**Consultation Response from KC,
Highways Development Management**

2025/93532 Bromley Farm Quarry, Barnsley Road, Upper Cumberworth, Huddersfield, HD8 8PD

Discharge of details reserved by conditions 6 (site preparation and clearance), 8 (BEMP), 9 (landscaping), 11 (fencing), 12 (WSI), 14 (shared access), 16 (access road), 19 (wheel bath), 22 (Access Management Plan), 23 (parking), 49 (surface water discharge), 59 (delivery HGV route) on previous permission 2023/91280 for quarrying operations for the extraction of clay, shale and incidental coal and subsequent restoration by means of importation of inert wastes

DRAWING TITLE
TYPICAL SECTIONS & LONG SECTION

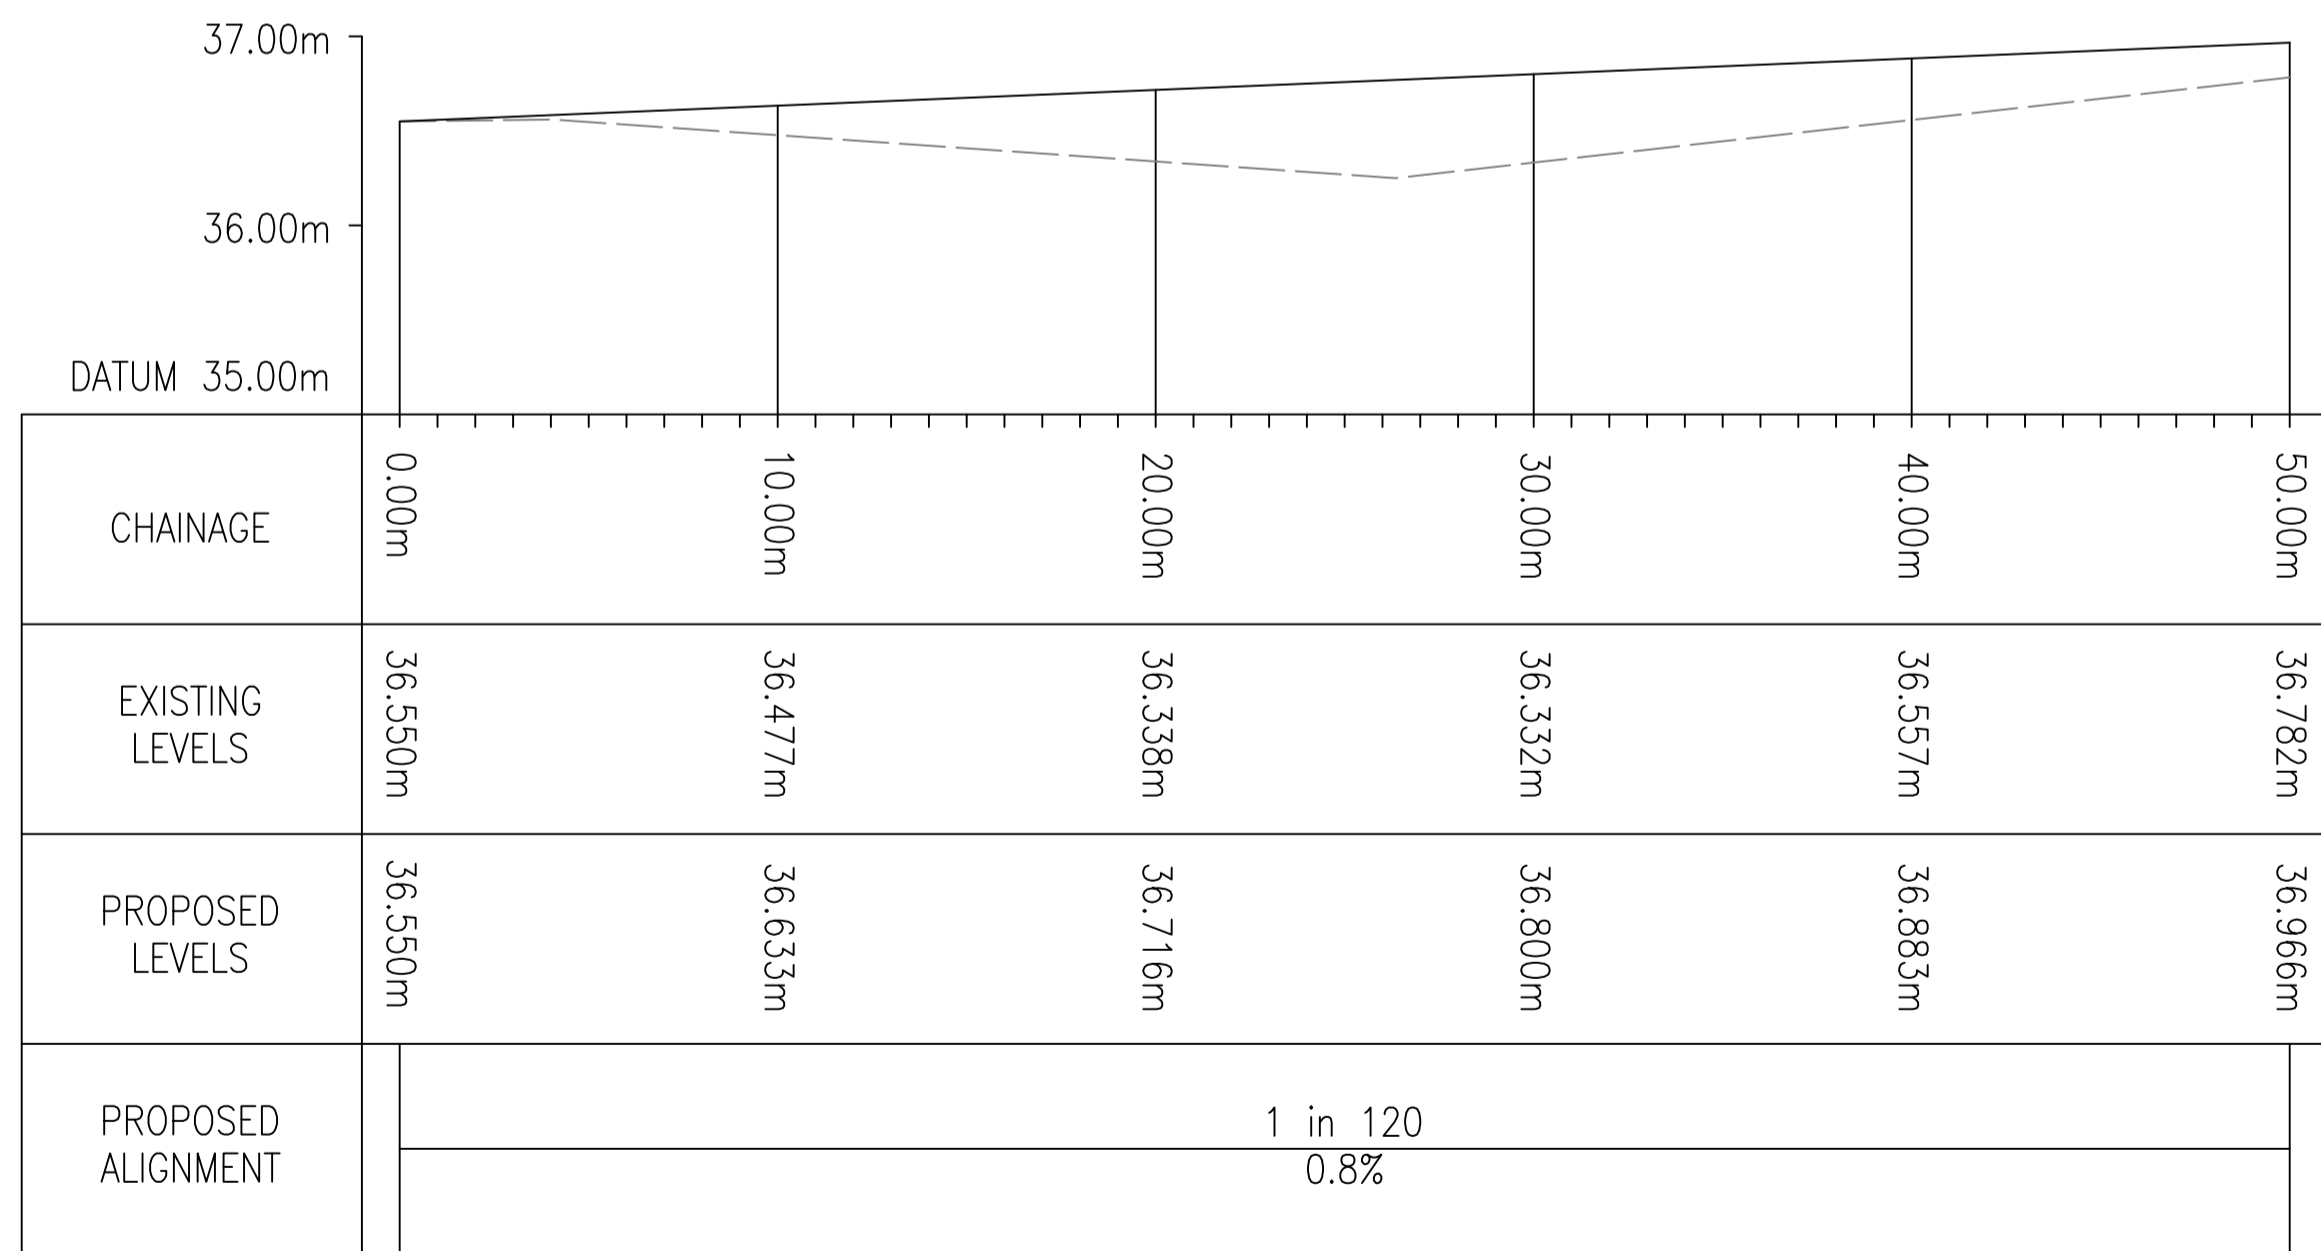
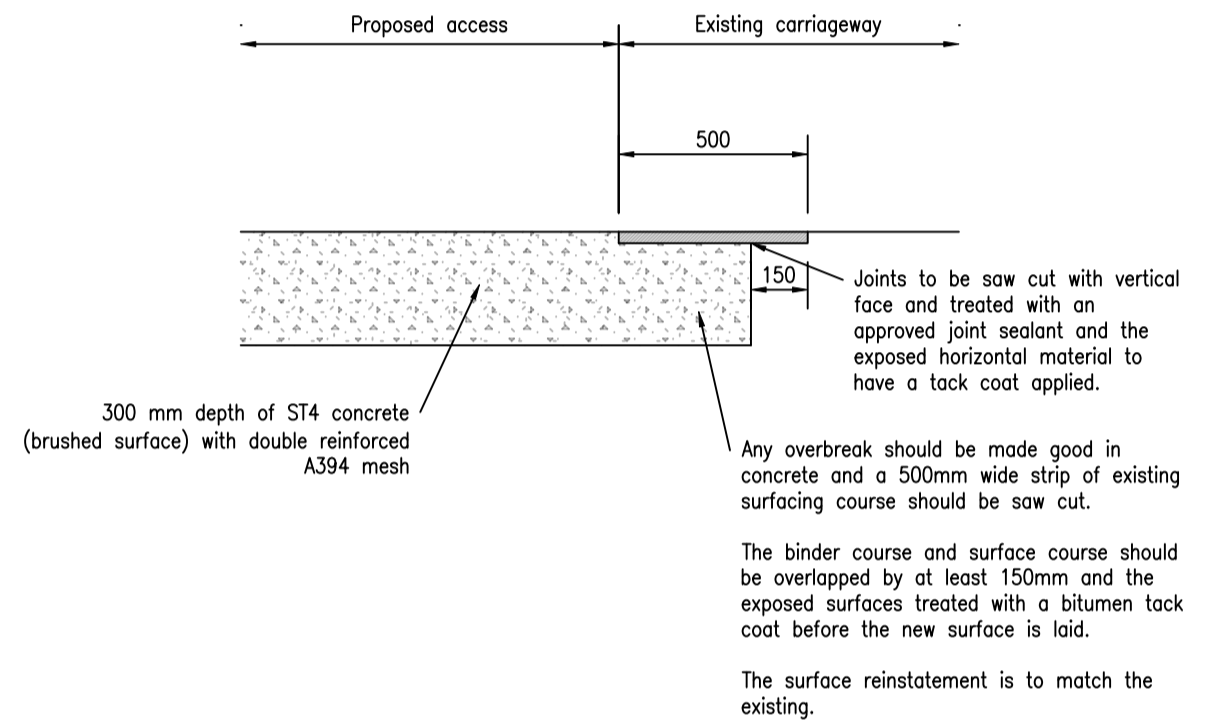
Details of the areas of workings to be undertaken to widen the shared access road to a minimum of 6m along its whole length is indicated in drawing CH0001 with the individual sections of widening being shown in drawings CH002, CH003 and CH004 Surfacing Viewports 1 to 3. These indicate the detailed areas to be constructed and the sections to be resurfaced to tie the new construction in with the existing highway. Drawing No CH0005 shows typical sections of the new construction showing the details of the course thicknesses and these all conform with the Kirklees Standard Details drawing No HD/SD/07/03c Pavement and Footway Construction and this is acceptable.

Details of the private site access road was shown on drawing No CH0004 indicating that a paved surface will be provided for the first 50m back from the junction with the shared access road with the construction details of the tie-in with the shared access road being presented in drawing No CH0005 which shows the access road being a 300mm ST4 brushed surface concrete pavement with sufficient binder and surface course overlap to join the two constructions sufficiently, and this is acceptable.

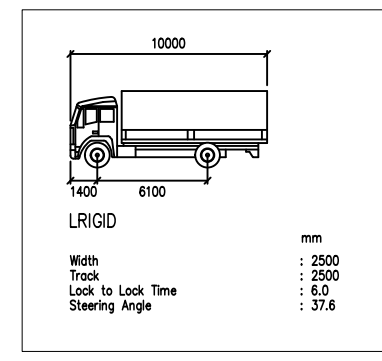
Details of the location of the wheel washing facilities are clearly marked on drawing No 2074 AMP 01A Site Plan provided as appendix A of the submitted Access Management Plan Rev A and this location is acceptable.

- Details of responsibilities and procedures for checking that no mud or debris is still clinging to the HGVs leaving the site, that may be deposited on the access road or adopted highway. Wheel bath facilities are to be installed, and details of its location is shown on drawing No 2074 AMP 01A Site Plan provided as appendix A of the submitted Access Management Plan Rev A and this location is acceptable. The wheel bath facilities are included within condition 19. No details were provided on who will hold the responsibility for carrying out the checks or ensuring any deployment of road sweepers if deposits are made on the highway. Details will need to be provided.

Details of the number of staff and deliveries to the site are included within the Access Management Plan and a suitable number of parking spaces are indicated on drawing 2074 AMP 01A Site Plan included as appendix A of the Access Management Plan, and these are acceptable.

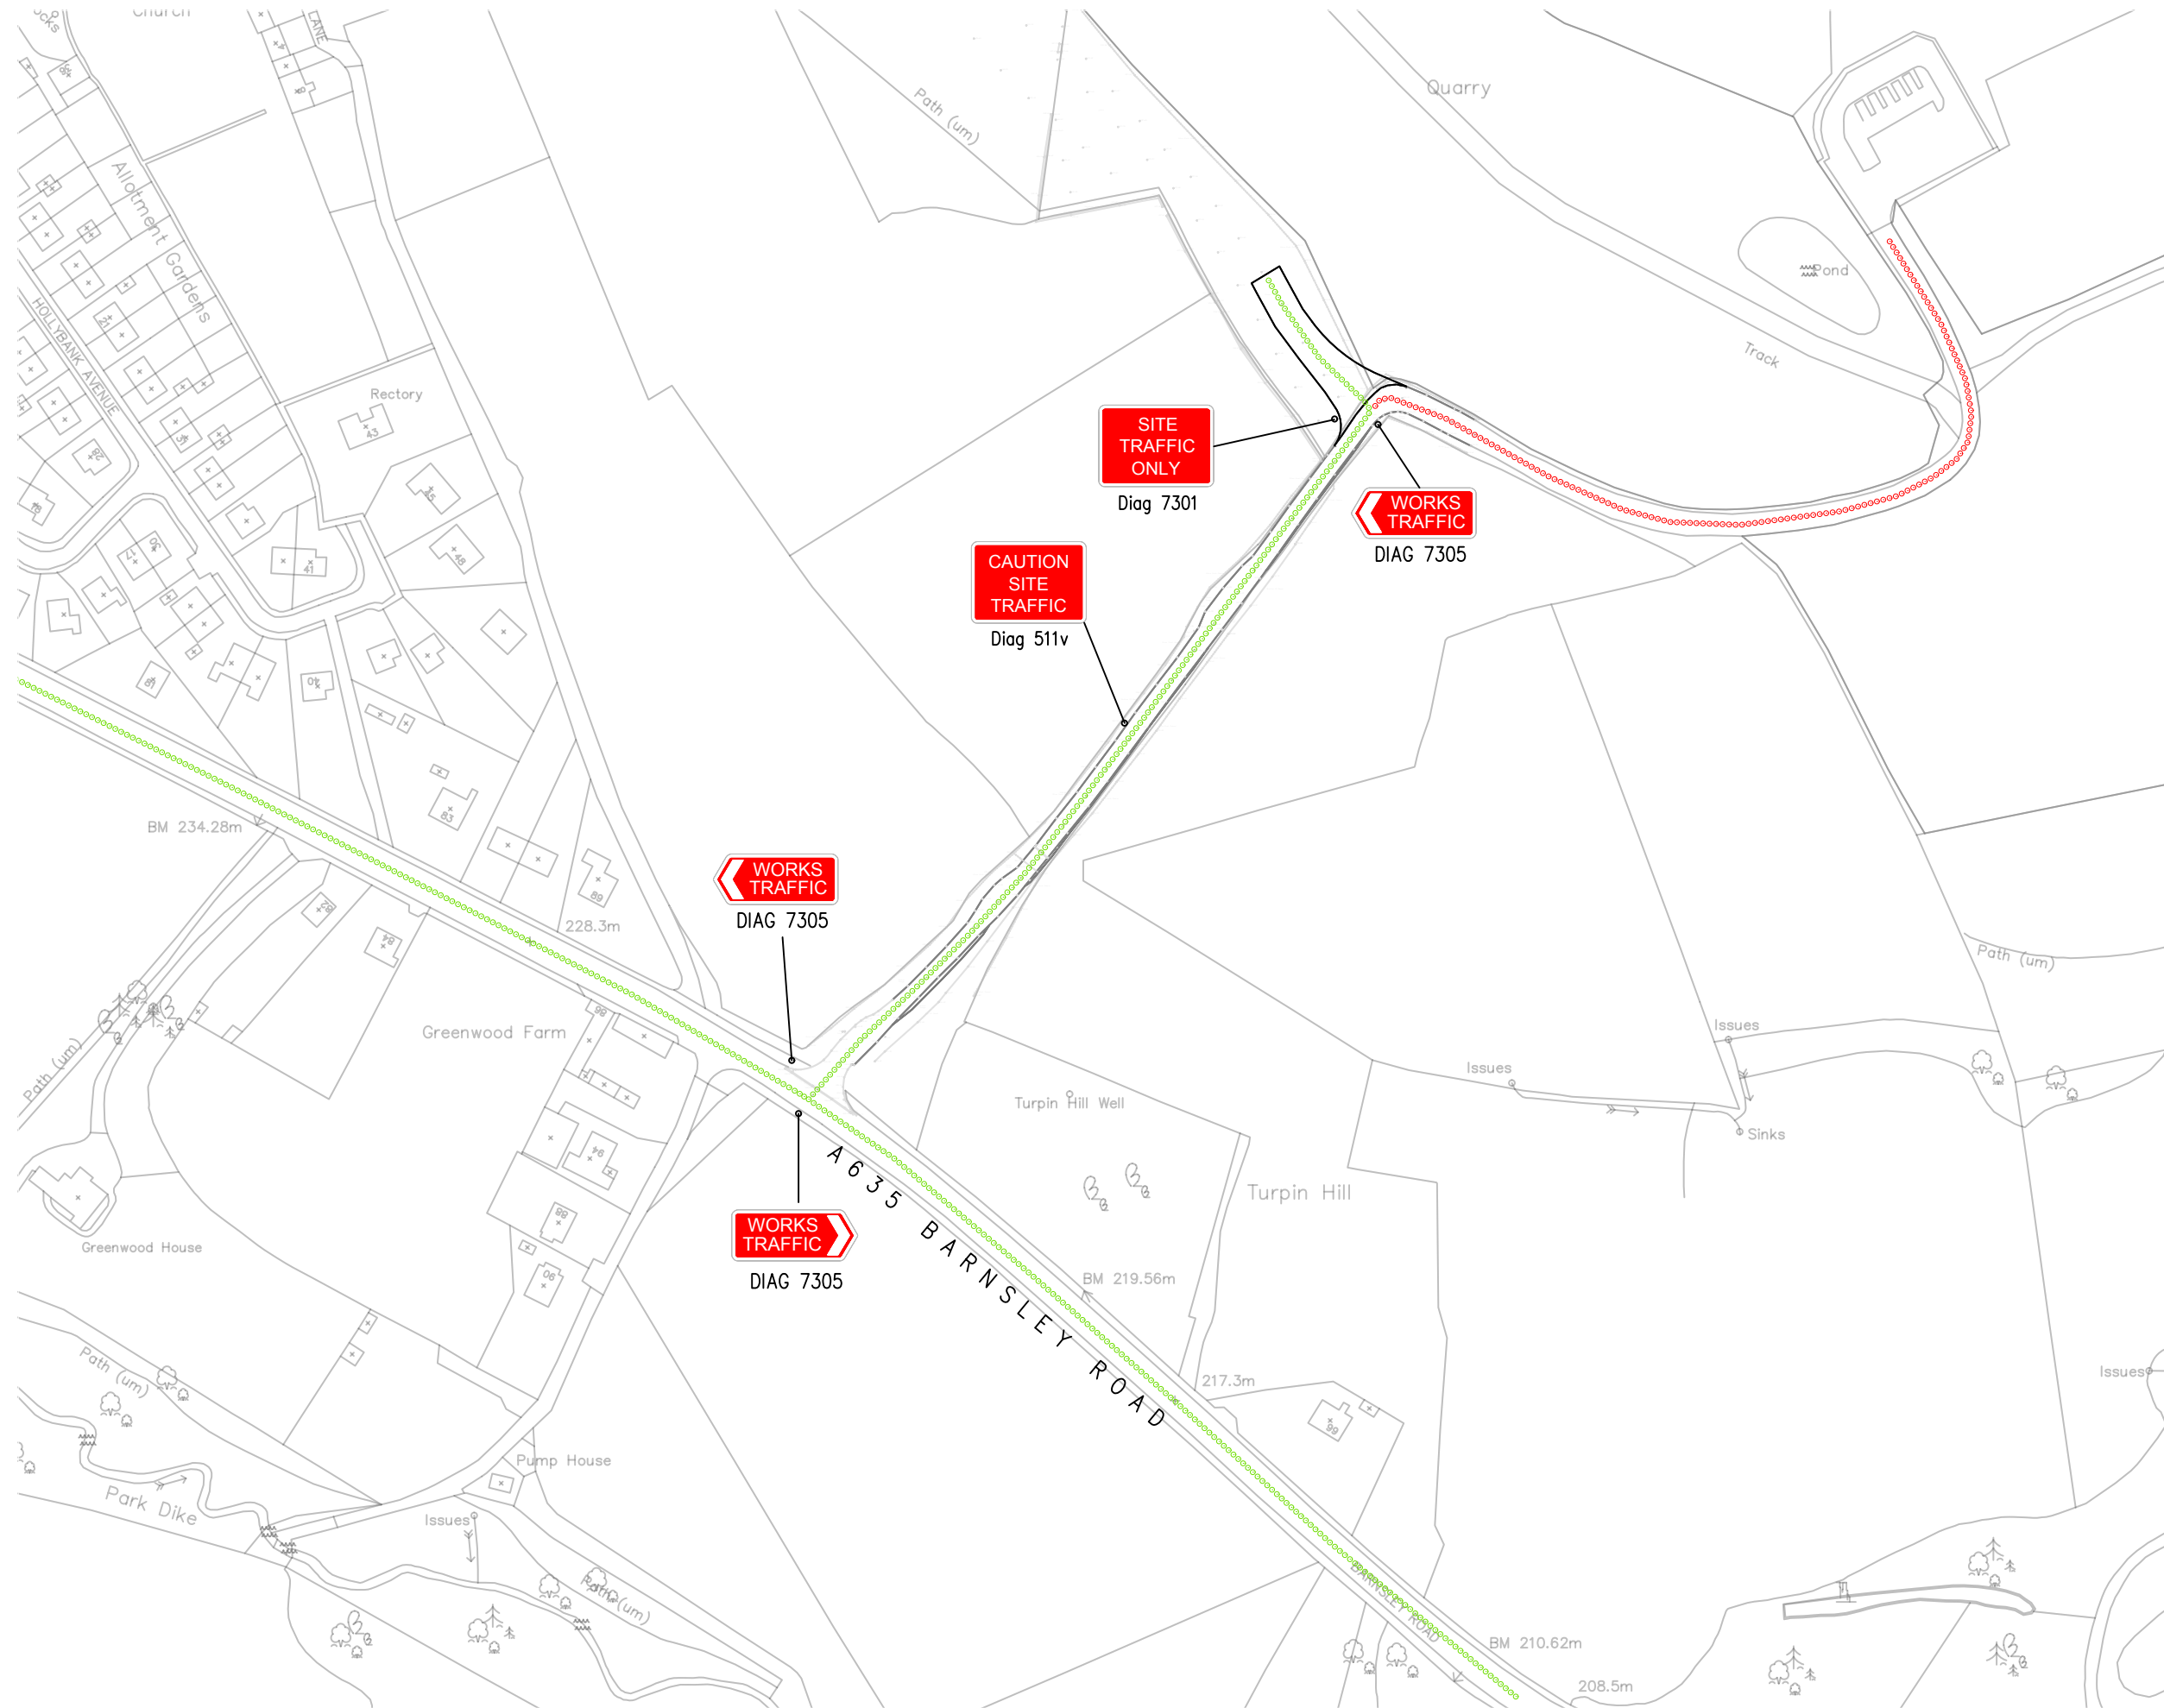
Signing on the route is indicated on drawing No AMP02A and provided in Appendix 2 of the Access Management Plan with details of the signs to be used provided in Section 2 Traffic Management and Control of the Access Management Plan, however it indicates that these signs will be temporary and will be removed at the end of the works. The applicant has confirmed by email (dated 28/04/26) that the Access Management Plan is for the operation of the quarry and not just the highway works period.
